Rezoning Transportation Analysis

Petition Number: 2020-039

General Location Identifier: Tax ID 12709221

Entitlement with Current Zoning	Apartments (R-22MF, .44 acres)	9 DU	50	General Guidance from Planning
Proposed Zoning	Townhomes	10 DU	75	Site Plan: 05-11-20

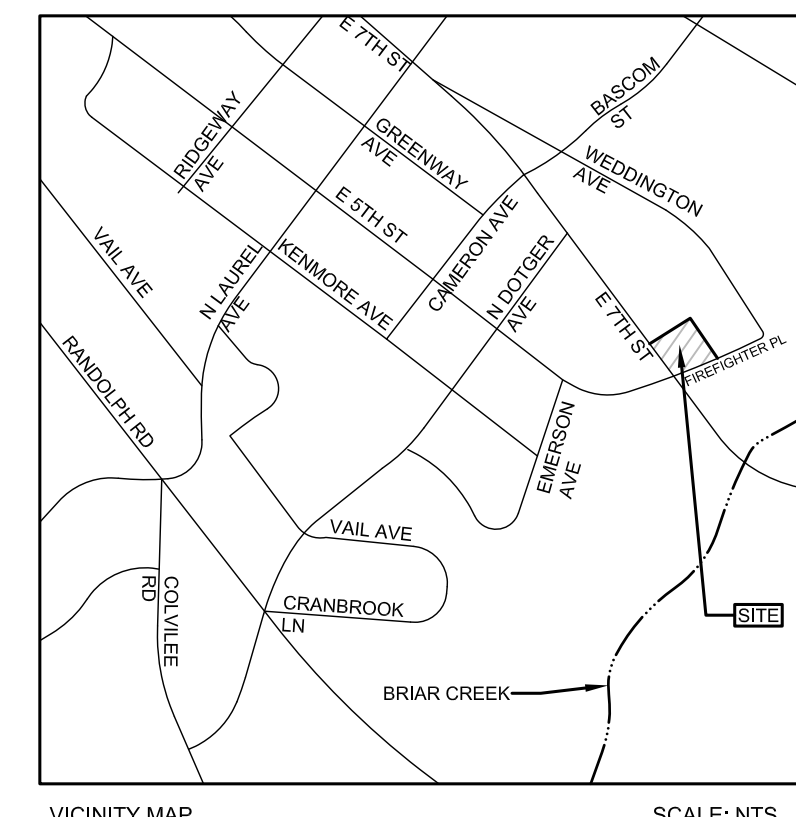
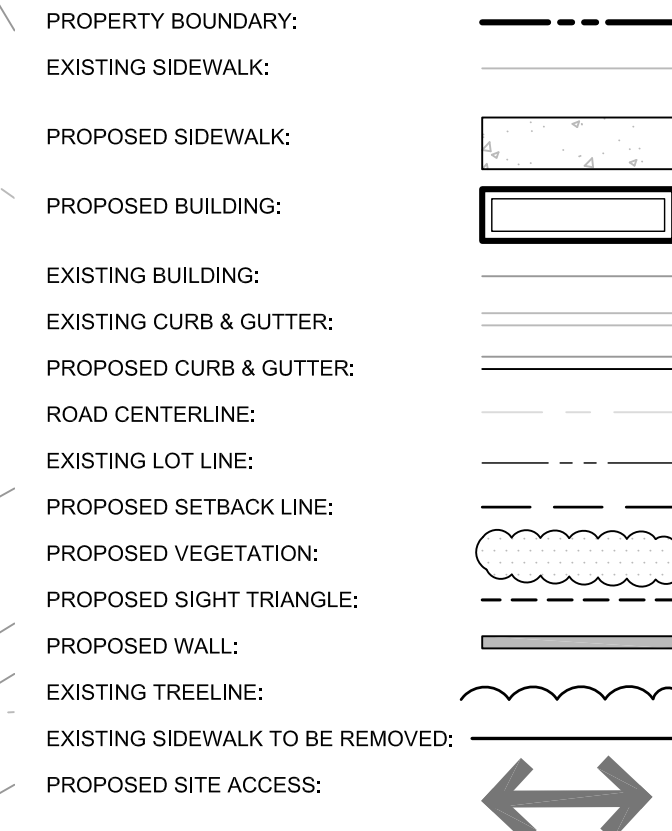
The site is located on a major thoroughfare road. The site plan commits to an 8-foot planting strip and 8-foot sidewalk along 7th Street and Fireplace Place. CDOT continues to request the construction of the accessible ramps and associated pedestrian signal improvements to meet Charlotte WALKS City policy and accessible ramp requirements to promote walkability to the nearby Briar Creek Greenway.

- The petitioner should revise the site plan and conditional note(s) to commit to construct dual ramps at the corner of E 7th Street and E. 5th Street to meet the City's Charlotte WAKS Policy and PROWAG. In addition, the developer should commit to provide accessible push buttons for its corner. The site plan should label and dimension both items from the back of curb and gutter and road centerline.

- We request for the petitioner should revise the site plan and conditional note(s) to commit to construct dual ramps at the corner of Monroe Road and E. 5th Street to meet City's Charlotte WAKS Policy and PROWAG. The site plan should label and dimension both items from the back of curb and gutter and road centerline.

6. The petitioner should revise the site plan to add a note specifying dedication and fee simple conveyance of all rights of way to the City before the site's first building certificate of occupancy is issued. CDOT requests right of way set at 2' behind back of sidewalk where feasible.
7. The petitioner should revise the site plan to add a note specifying all transportation improvements will be approved and constructed before the site's first building certificate of occupancy is issued. The petitioner may phase transportation improvements if said improvements and phasing are explicitly described in site plan notes.
8. ~~Resolved~~ ~~Sample format for comment that is resolved~~
